## Building

## Energy

DRAWN BY: D. F. GONZALEZ  
 ARCH FOUNDATION & EXCAVATION PLAN

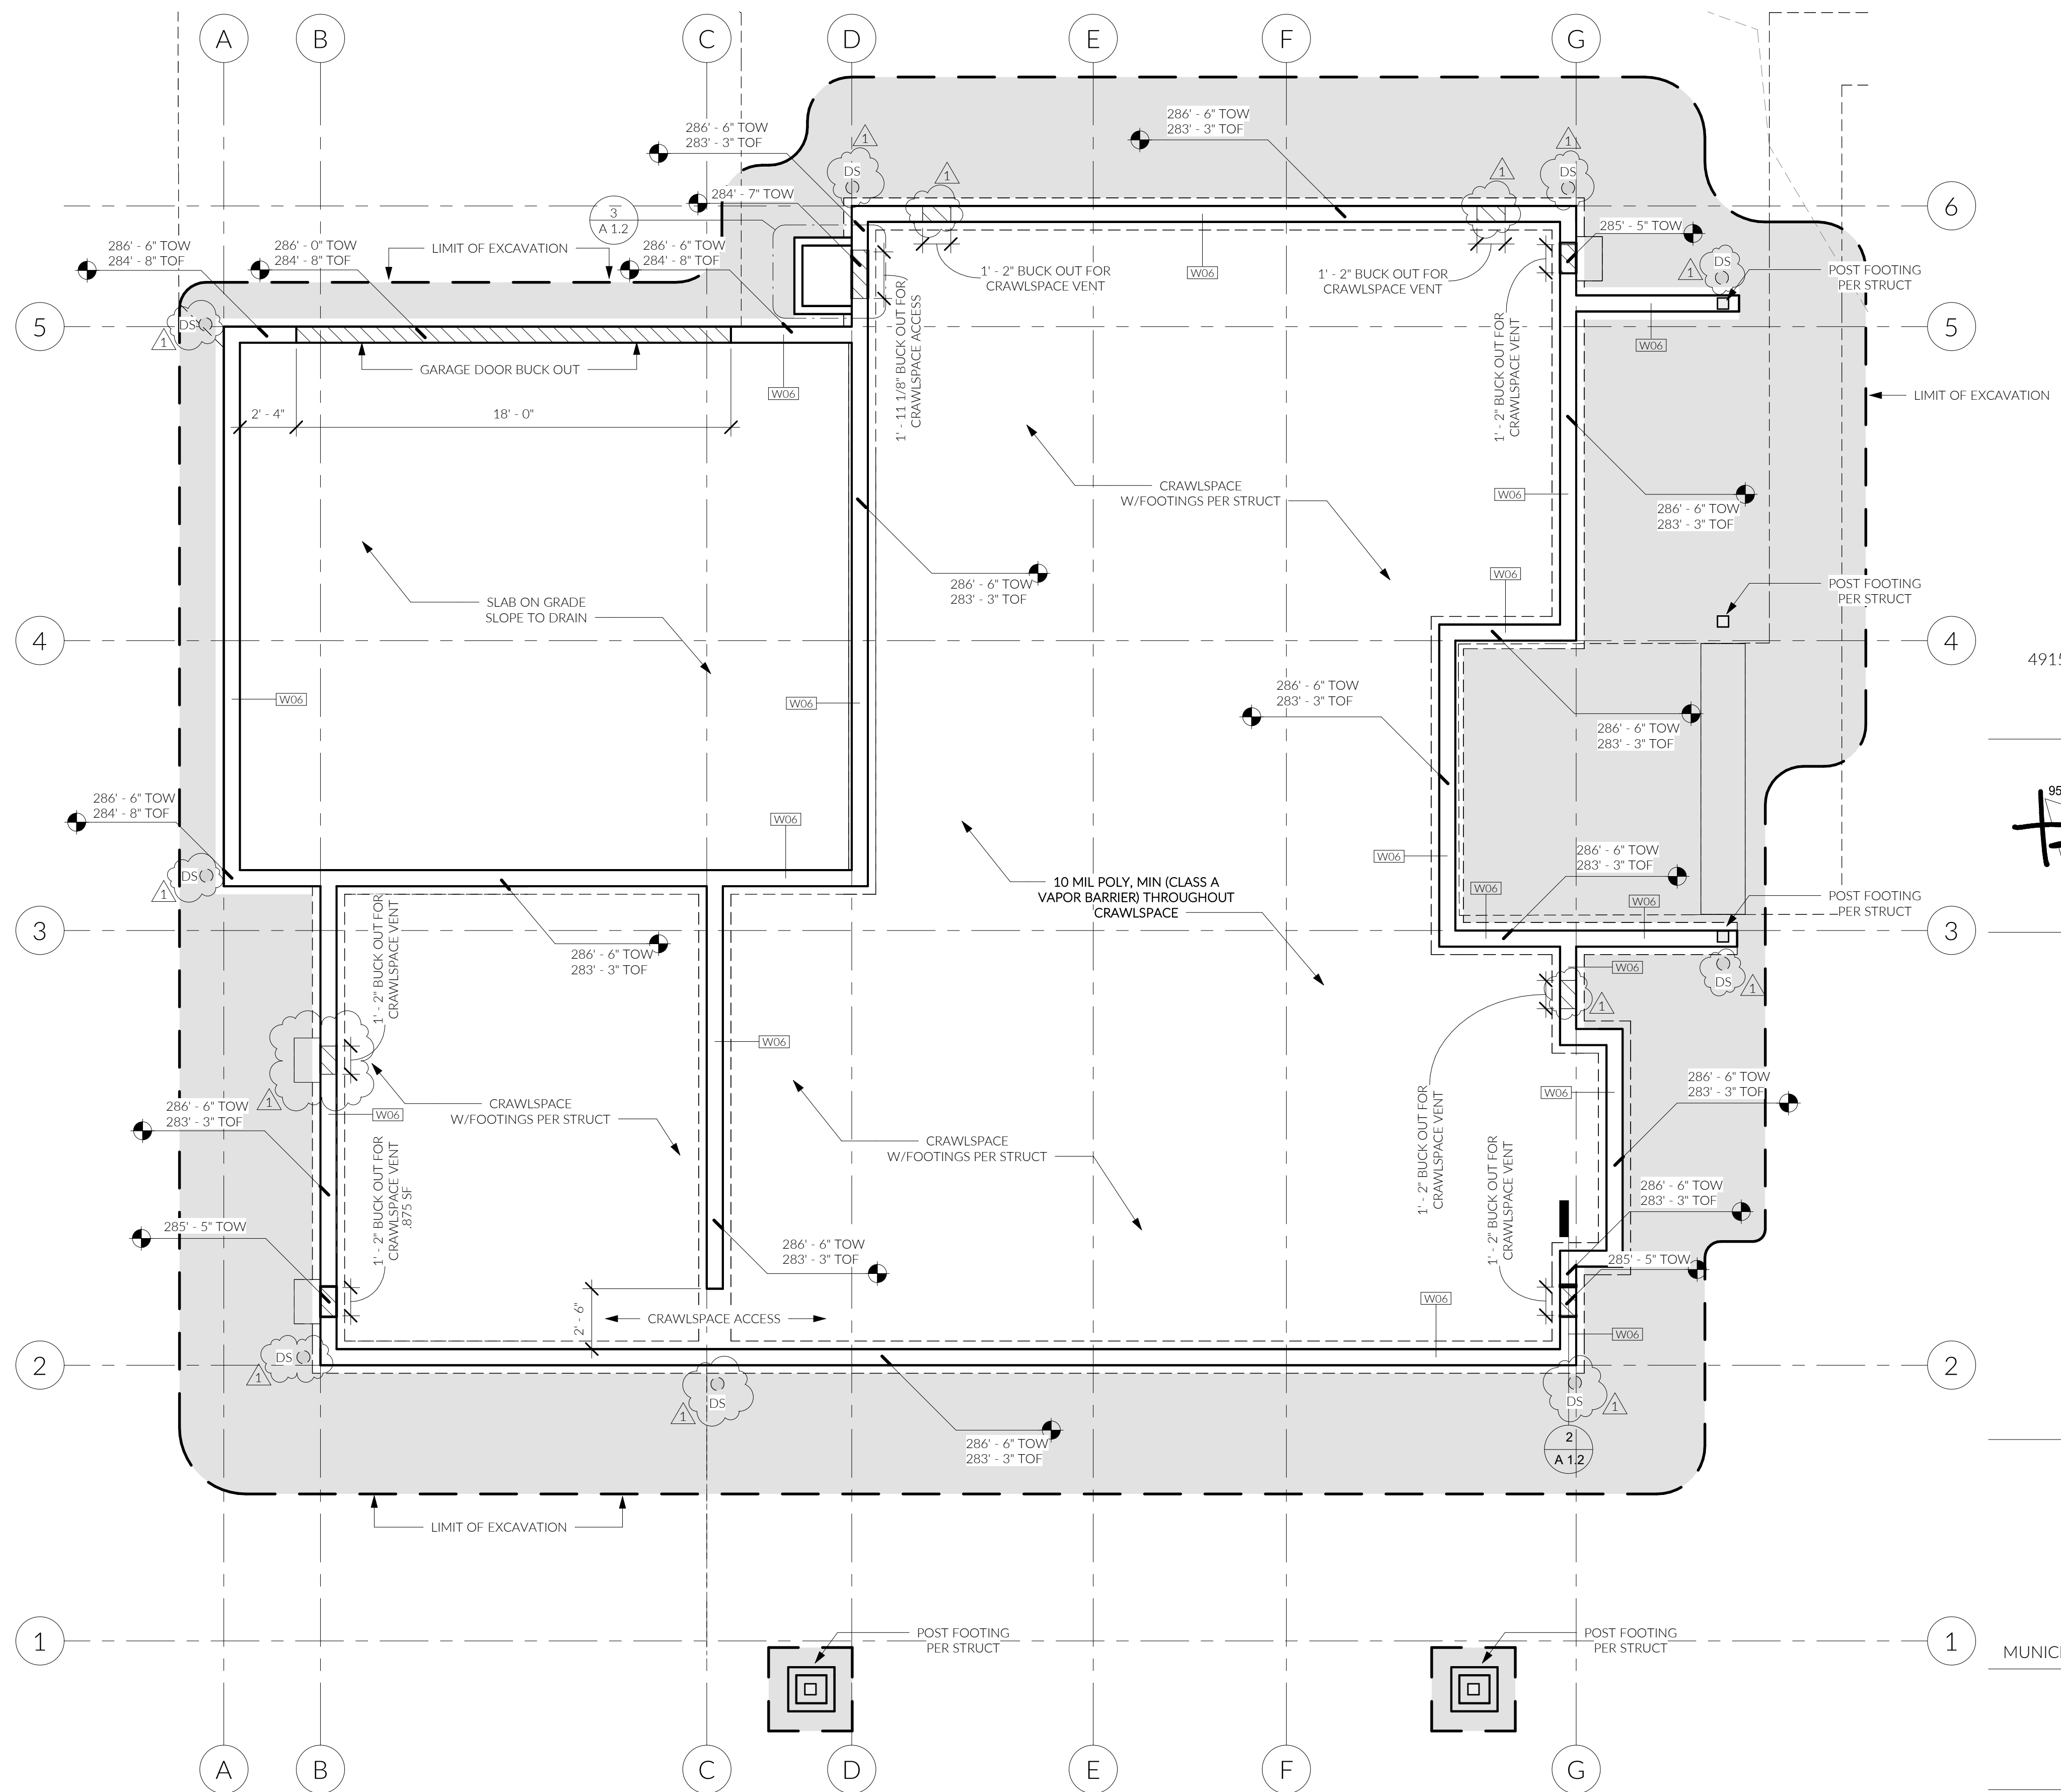
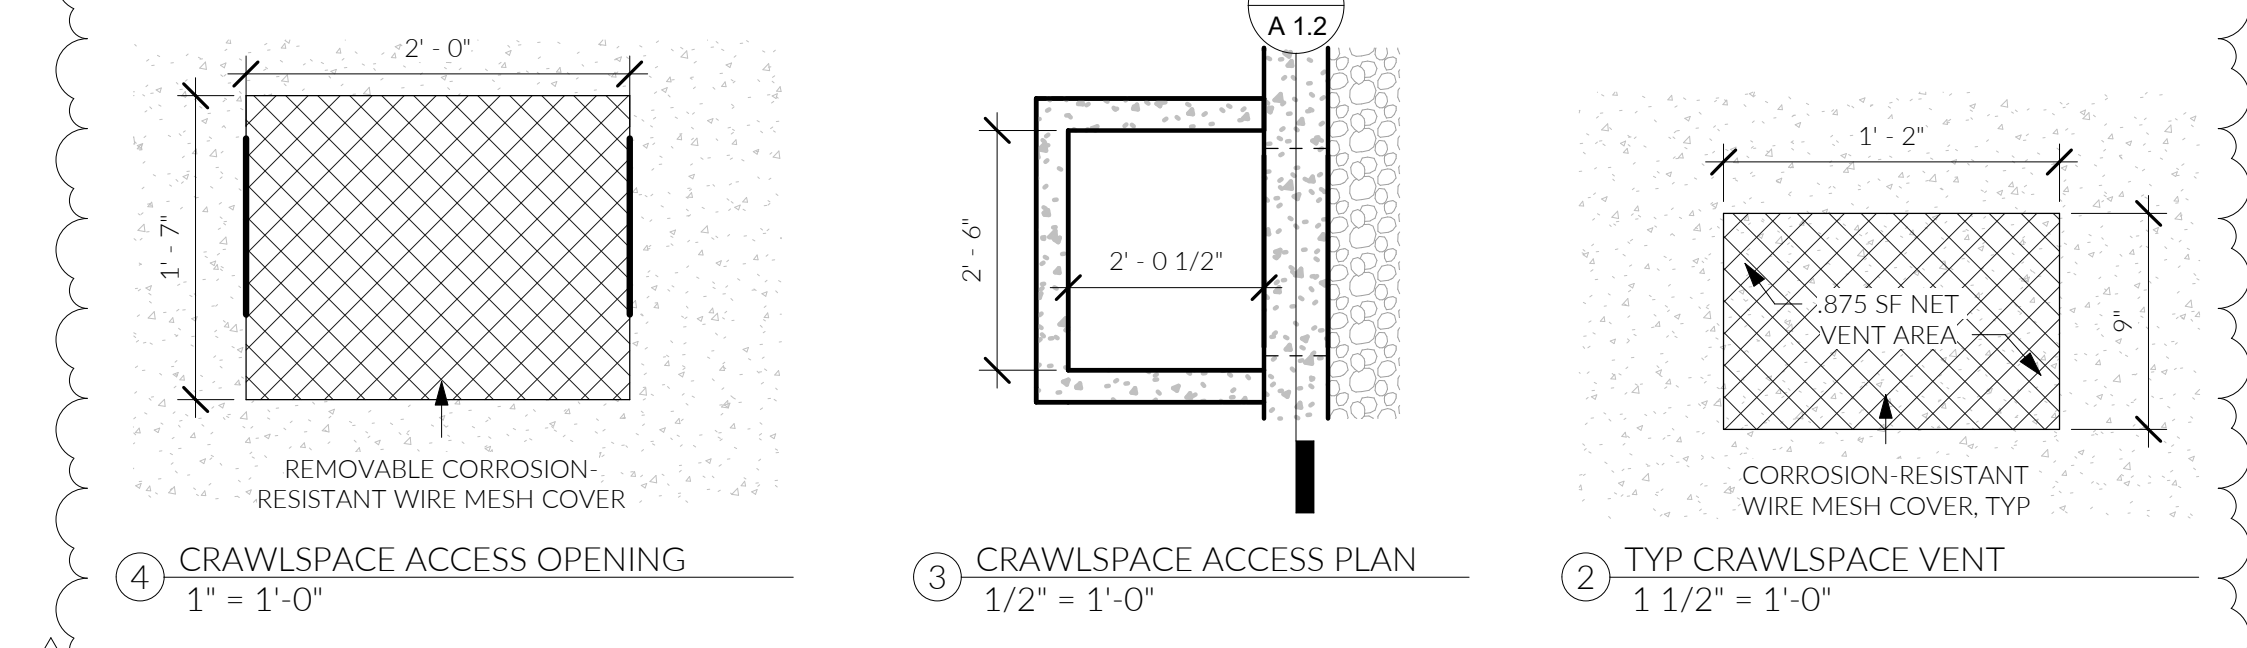
- a. *Detail added to sheet A5.0 showing relevant dimensions/requirements.*
- 7.) The crawl space ventilation calculations on Sheet A1.2 use a reduced ventilation area of 1:1,500. When applying the exception to IRC R408.2, you are required to incorporate a radon vent system into your design...

- a. *Minimum net area of ventilation and crawlspace ventilation updated. Please see sheet A1.2.*
- 8.) Sheet A1.2 shows the crawlspace vent opening width but does not show the depth. Please clarify the opening size and specify the provision of corrosion-resistant wire mesh...

- a. *Details and measurements added to sheet A1.2.*
- 9.) Crawl space access is required per IRC R408.4 to be 18" x 24" through floors or 16" x 24" through walls. It appears an exterior access opening is being provided...

- a. *Details and measurements added to sheet A1.2.*
- 10.) A 6-mil polyethylene or approved vapor retarded with joints lapped not less than 6" is required between the concrete slab-on-grade at the attached garage and the base course...

Section 2  
1/4" = 1'-0"

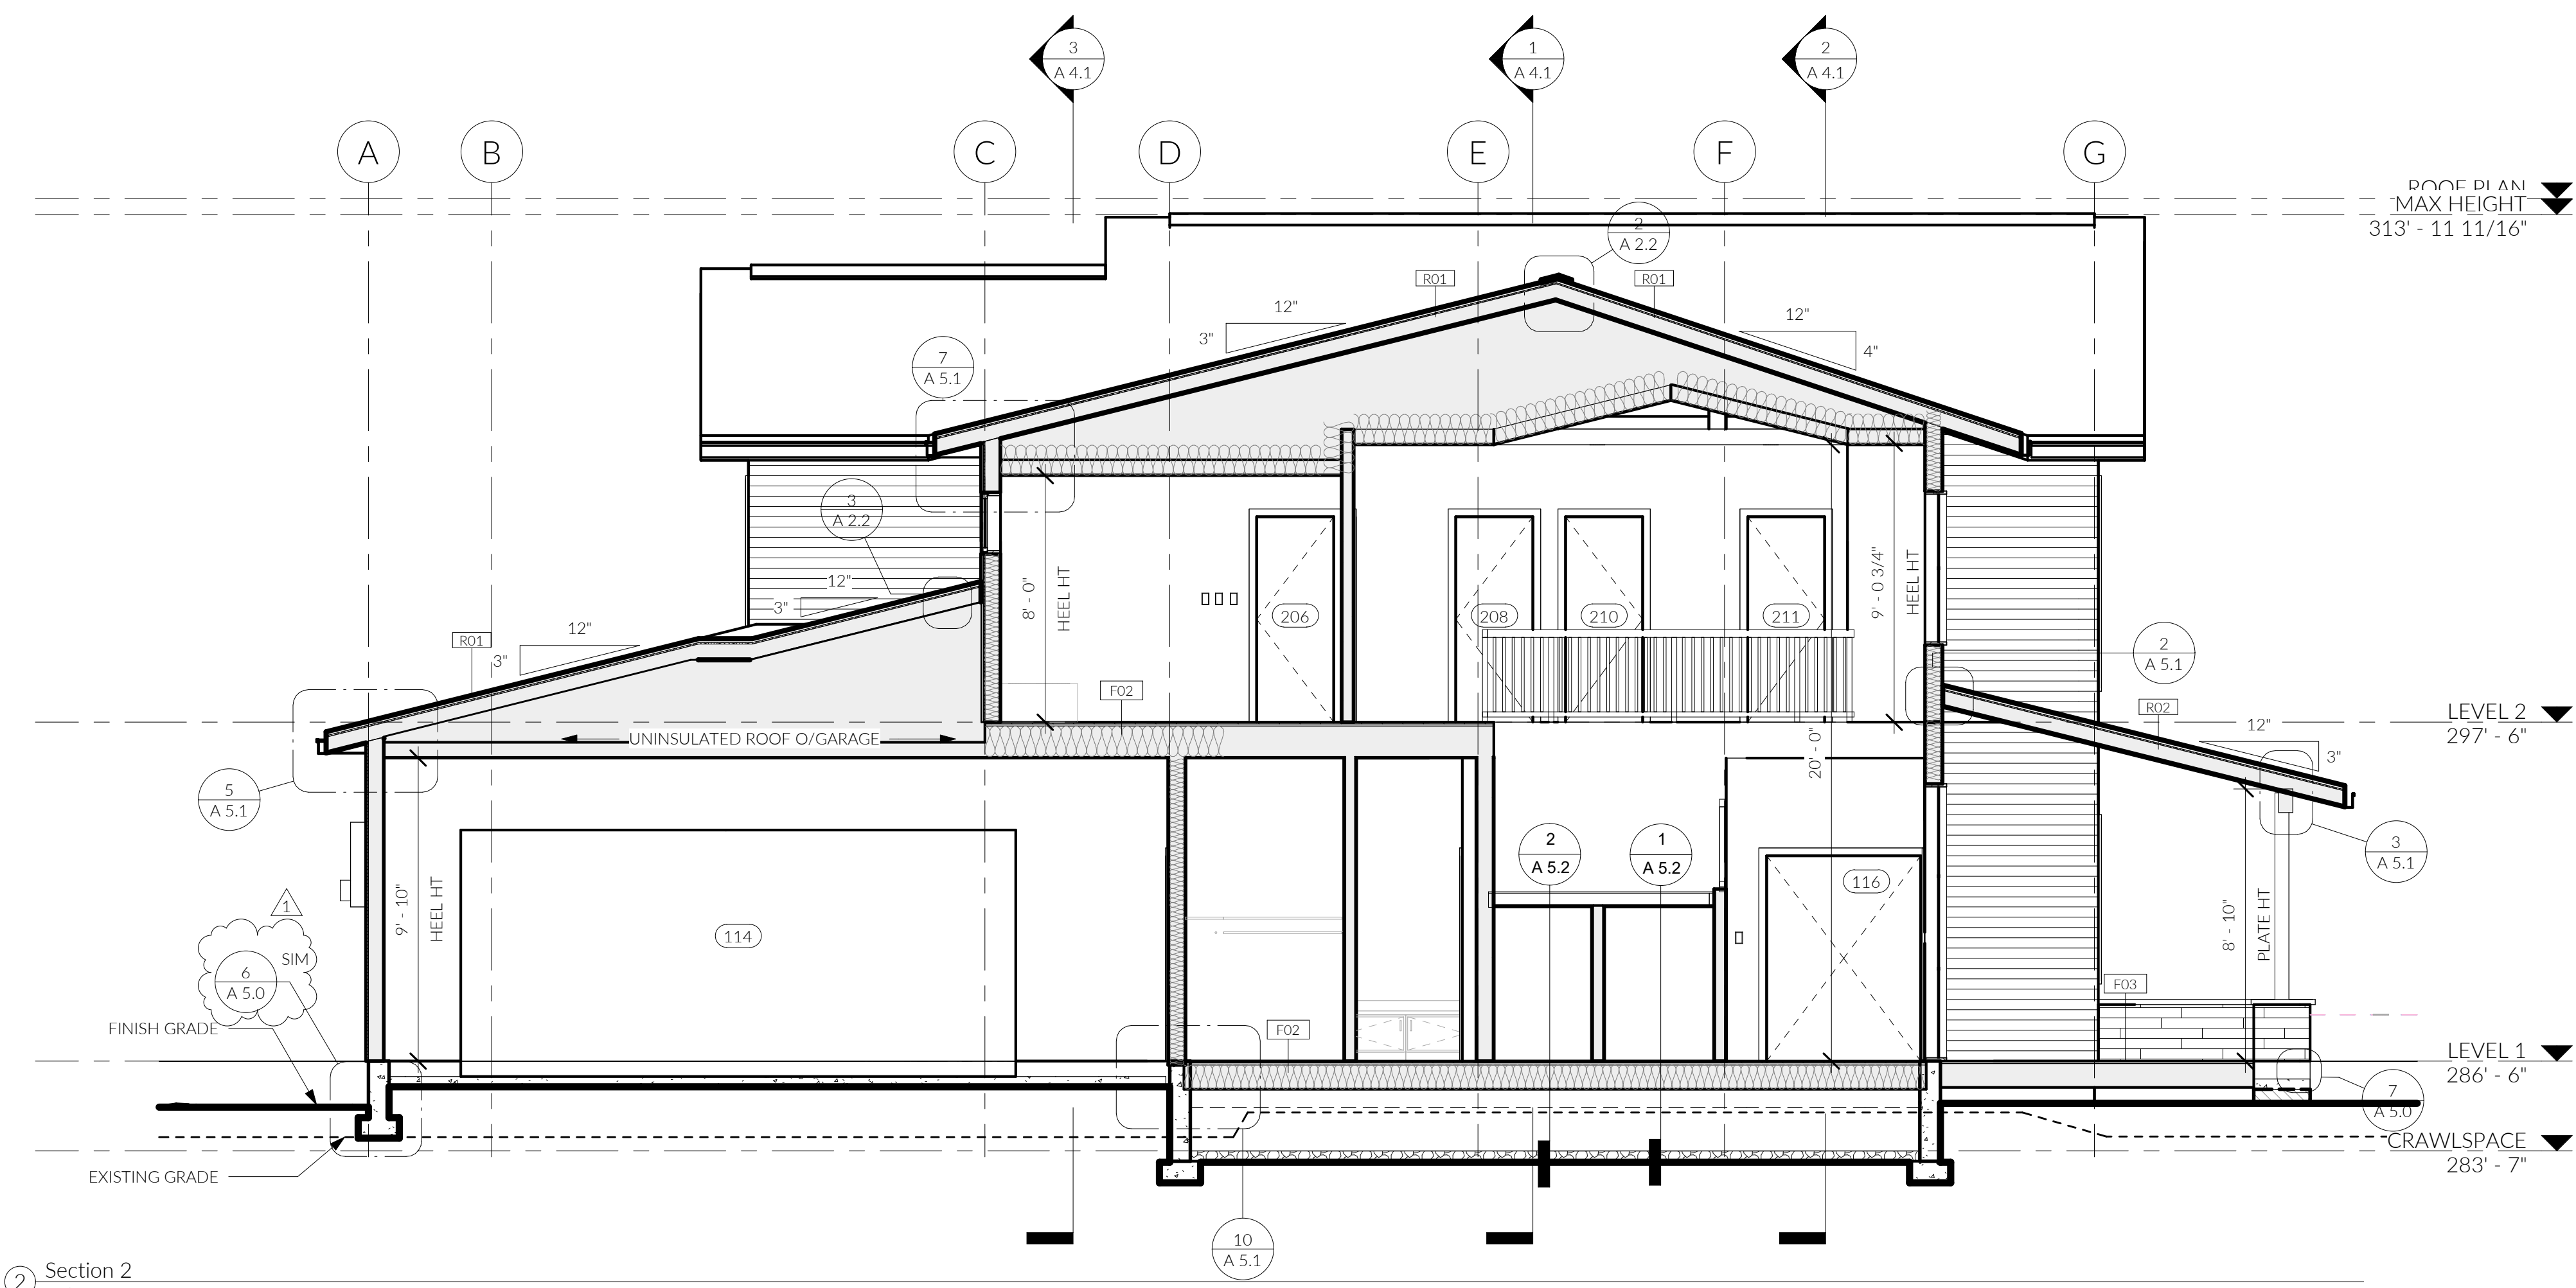
- 11.) Do the guard details on Sheet A5.0 apply at the upper floor opening? Section 2/A5.2 shows the guard spanning 12' between Grids 3 & 4; additional posts may need to be incorporated into the design.

- a. *Guardrail details updated. Please see sheet A5.2.*
- 12.) Please show roof drains in footing details.
  - a. *Roof drains shown on foundation plan. See sheet A1.2.*

7 TYP MASONRY CLEARANCES  
3\"/>

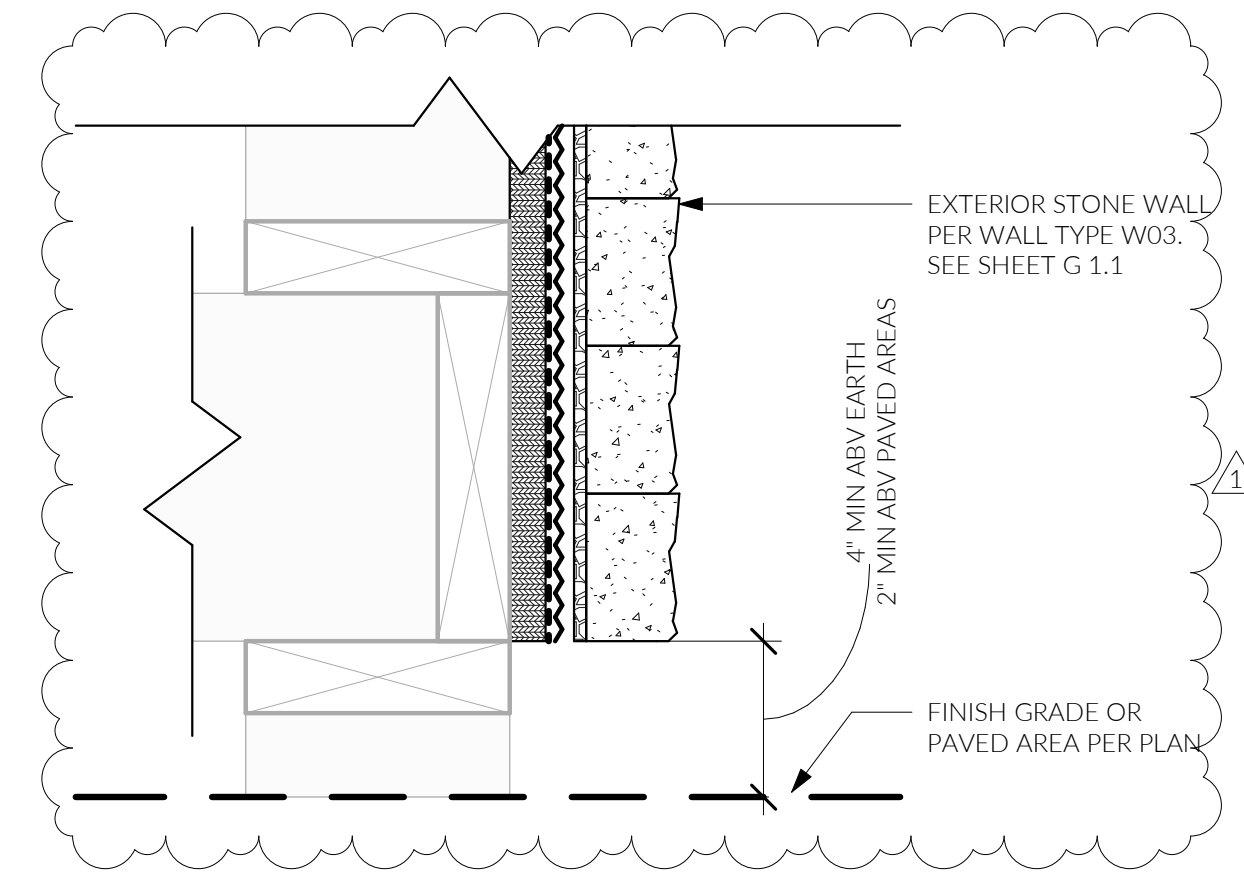
- 13.) Adhered masonry veneer is required to have the following clearances per IRC R703.12.1: 4" minimum above the earth, 2" minimum above paved areas...

- a. *Detail added to sheet A5.0 showing relevant dimensions/requirements.*
- 14.) Enclosed attics and rafter spaces must have cross ventilation for each space per IRC R806.1. The minimum net free ventilating area of 1:150 must be provided unless the provisions of the exception...
